Major Projects Assessment
Department of Planning and Infrastructure
GPO Box 39, SYDNEY, NSW 2001

**ComfortDelGro Cabcharge comments on SSI-5100
North West Rail Link Environmental Impact Statement 1**

PCU033976

Figure 4.4 Castle Hill Station Heavy Vehicle Routes

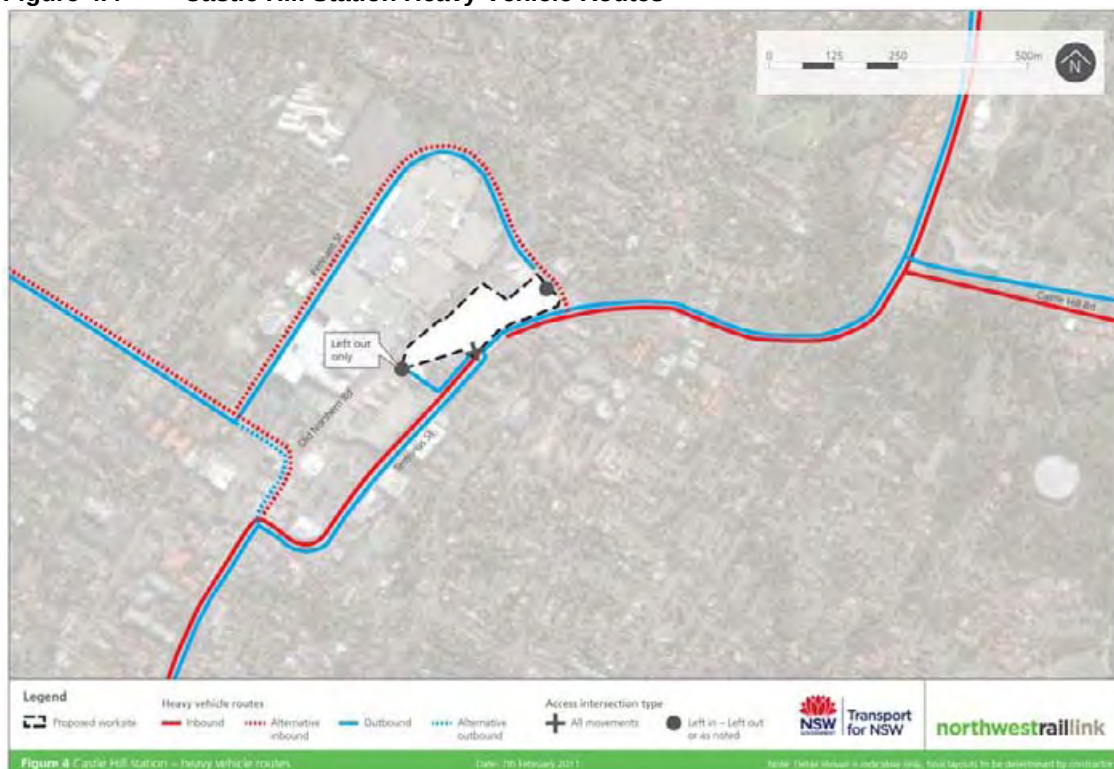
CDC is concerned with the dual traffic proposed for Old Castle Hill Rd in what is proposed as a replacement interchange whilst construction occurs. Old Castle Hill Rd currently experiences a very high level of bus activity as the major centre for the Hills district. Buses and general traffic currently only operate in one direction of Old

Castle Hill Rd between Castle St and the roundabout to the Castle Towers car park entry at Eric Felton St.

Three core issues arise from the proposed plans:

- Current layover areas will have to be relocated, but no site has been proposed. CDC is working with the NWRL to identify suitable areas, however it must be stated that any solution may be remote from the current interchange and impose significant additional time costs in terms of repositioning of buses and provision of meal/toilet facilities for drivers.

- Relocating all bus services currently using Castle Hill Interchange Stand C into Old Castle Hill Rd will significantly increase the risk of collision between buses, between buses and cars, and between buses and pedestrians. Solutions providing remedies to these risks must be provided.

- Hillsbus currently serves four major destinations from Castle Hill Interchange, being Sydney CBD, North Sydney, Macquarie Park and Parramatta. In addition the interchange is a major hub for school services in the Hills district. The current peak hour frequencies require that a minimum three buses be able to pick up at any one time. This is expected to grow further over the construction period of the station. Rank and layover capacity must be secured and constructed to provide sufficient capacity (including growth) for the full period of construction so as to avoid further impacts and uncertainty on the local bus operators and their passengers.
